Our ref: OUT23/20339

Subject: Calala Battery Energy Storage System (BESS) (SSD-52786213) - Environmental Impact Statement (EIS)

Advice to DPE Planning & Assessment regarding the Calala BESS - EIS

EARTHWORKS CUT FILL PLAN

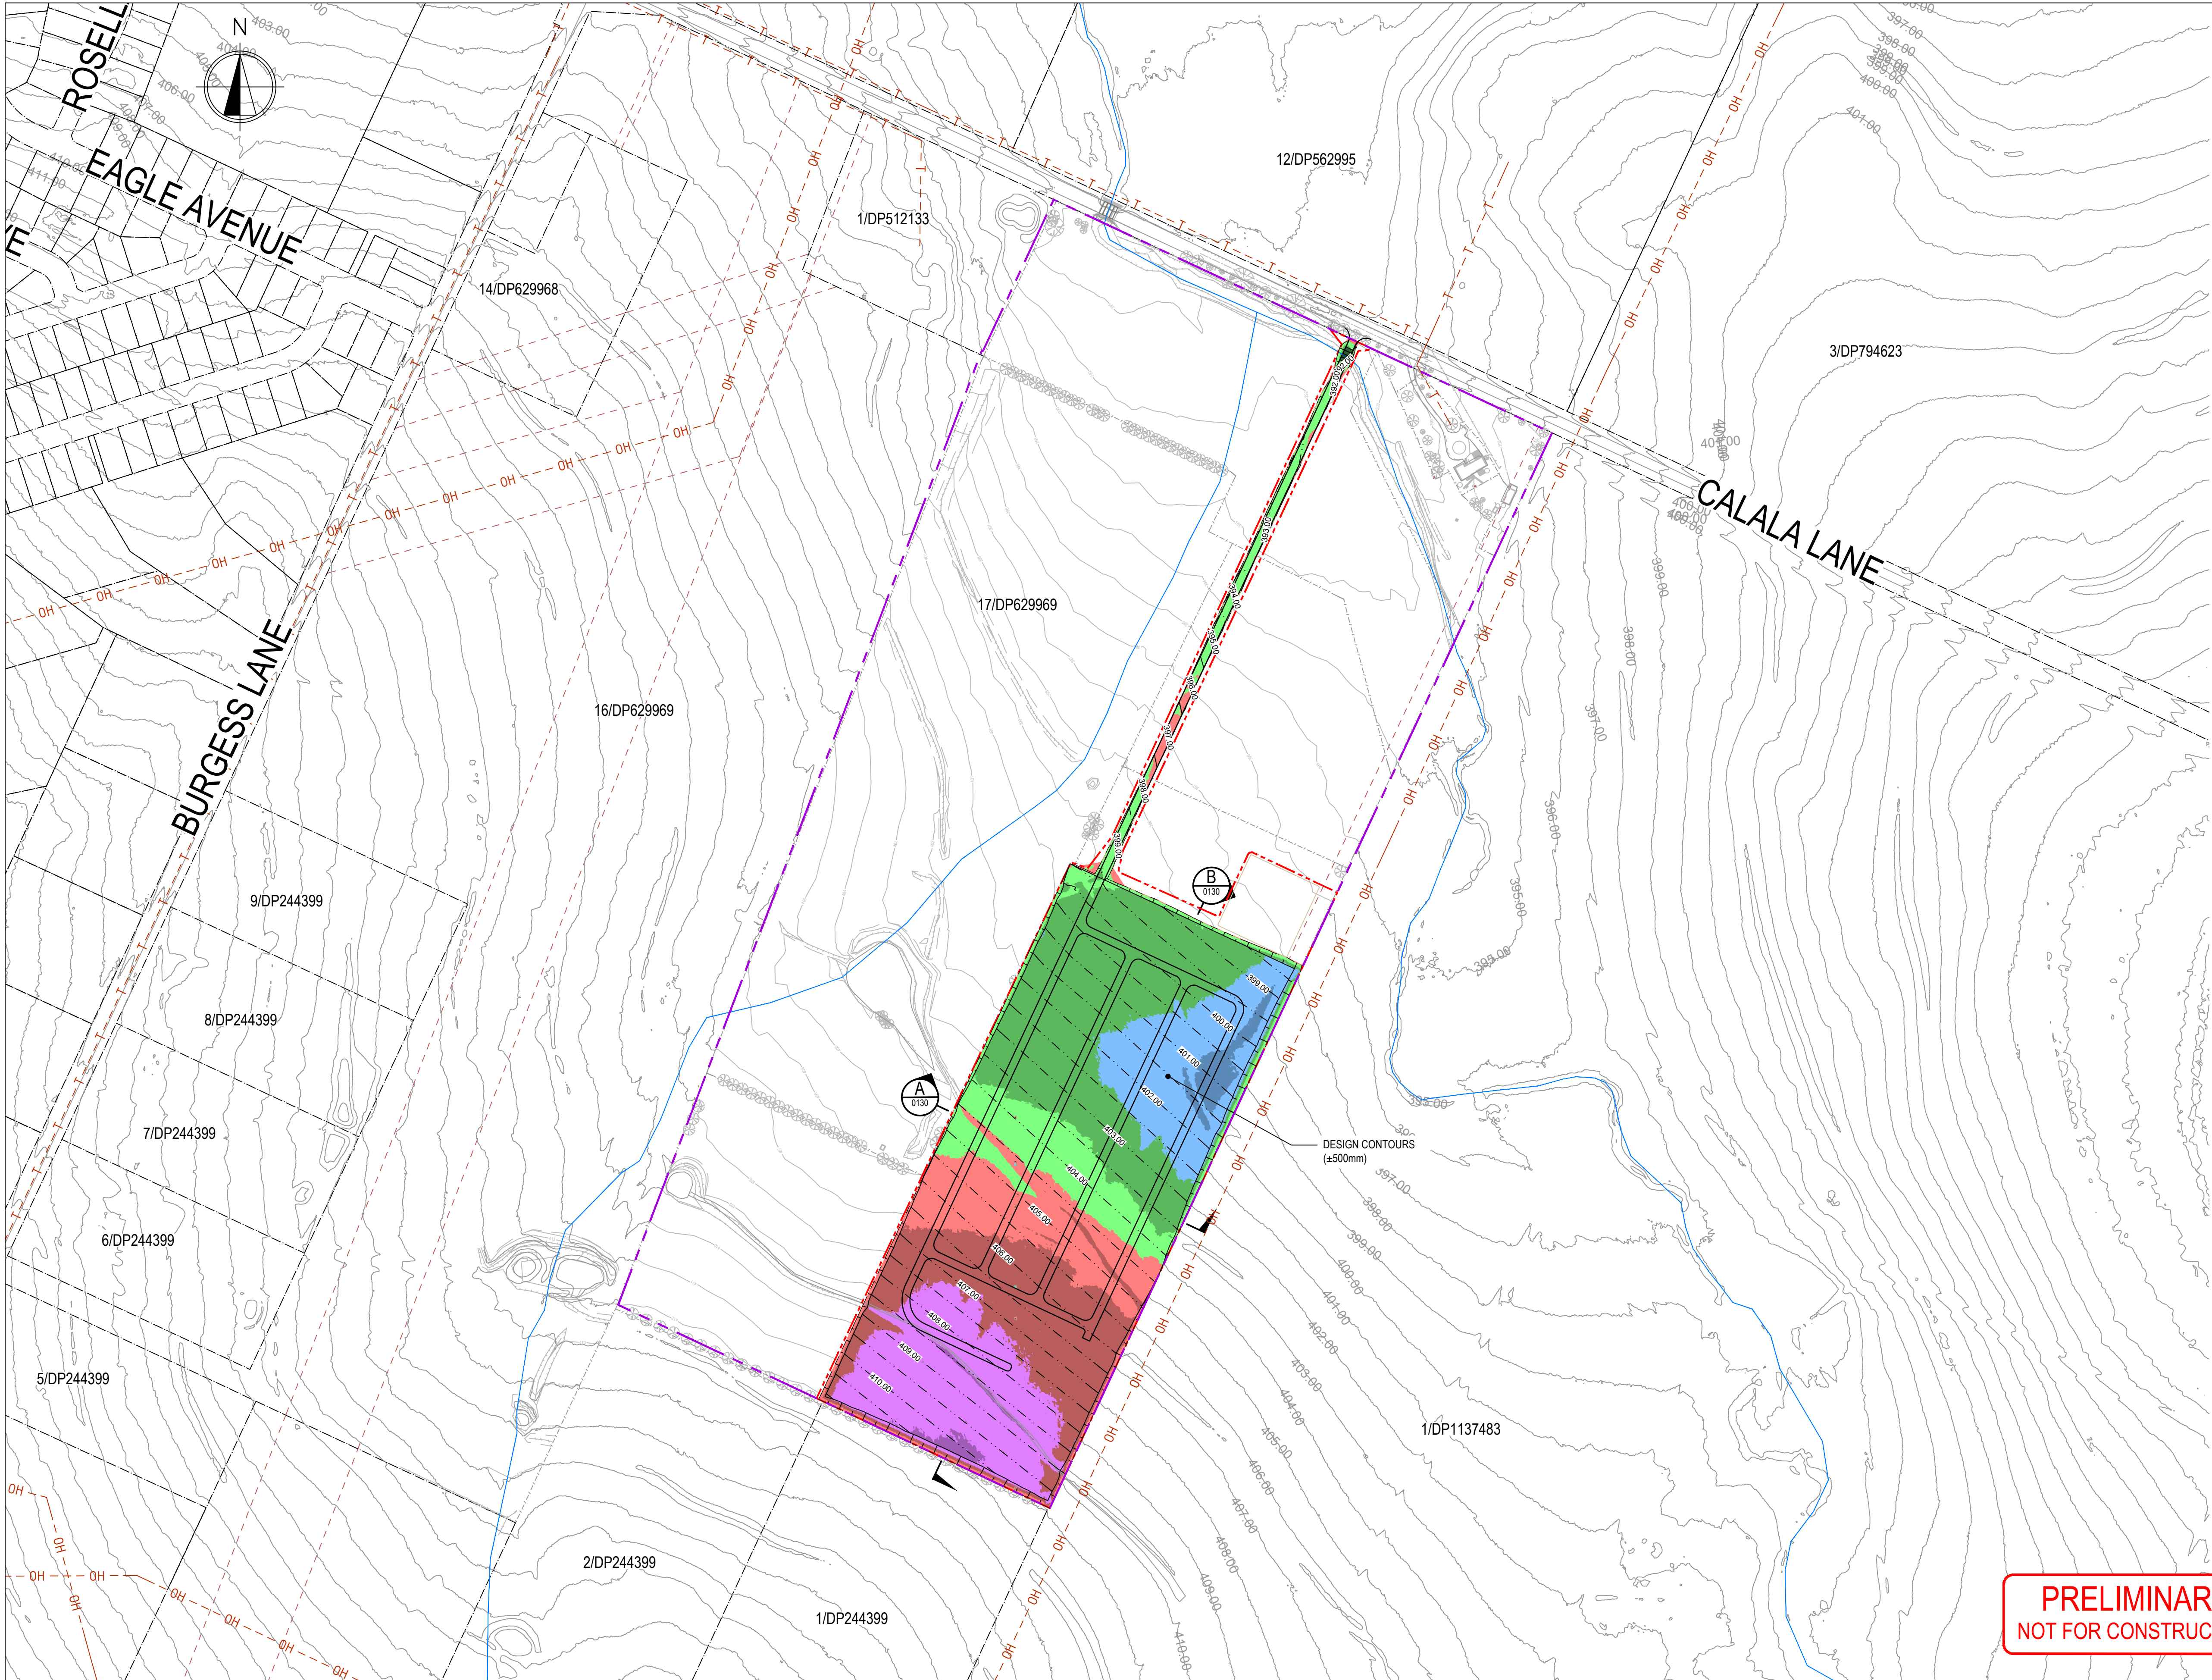
The proponent should clarify whether groundwater will be intercepted due to the project's excavations.

The project will require excavations to provide suitable pad areas to accommodate the BESS infrastructure, however, there has been no assessment of whether groundwater will be intercepted by the project's excavations. If groundwater interception will occur due to the project's excavations, the maximum volume will need to be quantified and a Water Access Licence with sufficient entitlement to account for the groundwater take must be obtained, unless an exemption applies.
